About the application

Application number: 2021/90702	
What is the application for?:	Variation conditions 2 and 3 on previous permission 2018/94167 for erection of d
Address of the site or building:	adj, 27, Riley Park, Kirkburton, Huddersfield, HD8 0SA
Postcode:

DRAWING DESCRIPTION			
Proposed Elevations & Site Plan			
JOB TITLE			
27 RILEY PARK KIRKBURTON			
CLIENT			
Mr & Mrs C TAYLOR			
DRAWN BY		SCALE 1:100@ A1	
DATE JAN 2021		DRAWING NO. 1102-03	
CHECKED		REVISION B

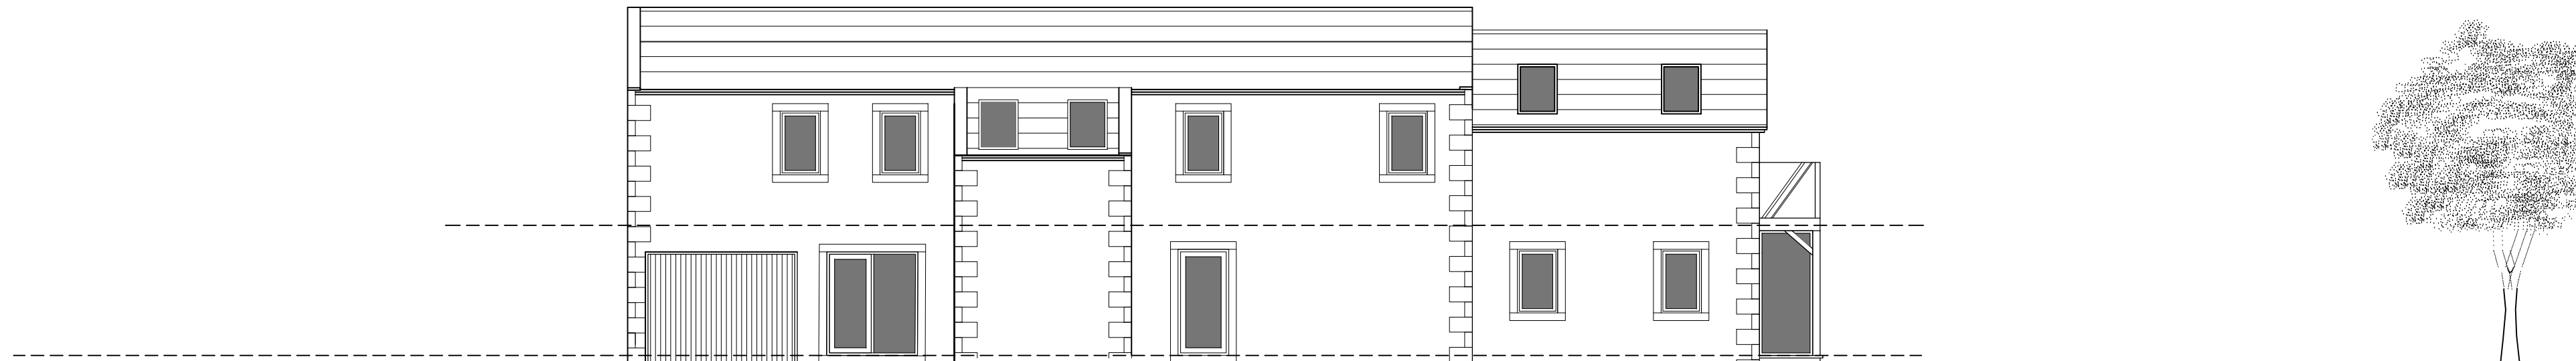
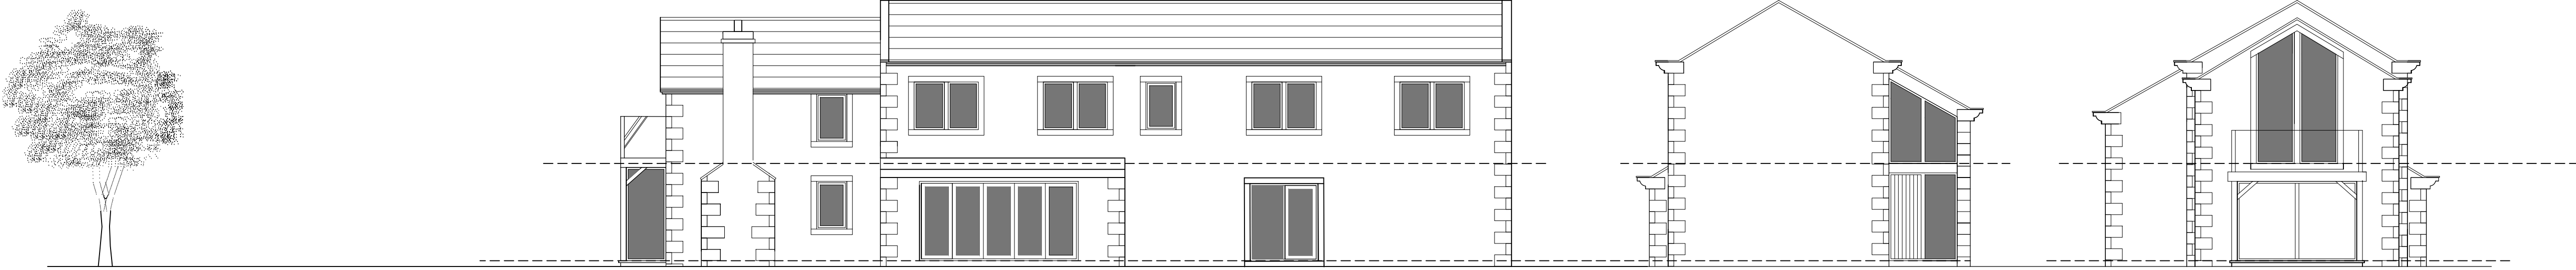
This variation to the plans increases the size and positioning of the building. The building moves to sit directly on the boundary with 27 Riley Park and extends further into the plot.

This with the large amount of additional fenestration completely changes and intensifies the overlooking issues and brings additional habitable windows of our property into those being overlooked.

This variation will cause direct overlooking into; the lounge, two second floor bedrooms, ground floor patio doors of the garden room, first floor kitchen window, first floor patio doors leading to sun decking from the kitchen and a third floor master bedroom. Therefore leaving us with very little privacy in our accommodation.

The documents provided with the Variation do not clearly identify the new relationships with 14 Low Town or any of the other neighbouring properties. Distances between habitable windows have not been confirmed.

Taking into account the larger proposed size of the proposed building, re-siting of the proposed building on the plot, additional fenestration and additional features such as the bi-fold doors being stepped out from the building towards our property by what appears to be in the region of 0.5m the relationship this proposed building has with 14 Low Town or any of the other neighbouring properties must be re-determined and re-assessed.

This variation changes materials of construction from natural stone to block and render.

Block and render will not meet the requirement for traditional and sensitive materials. Block and render painted white or a light shade on a building of the proposed size and scale will be overbearing when viewed from 14 Low Town and neighbouring properties especially when considering the height at which it will sit above the properties affected.
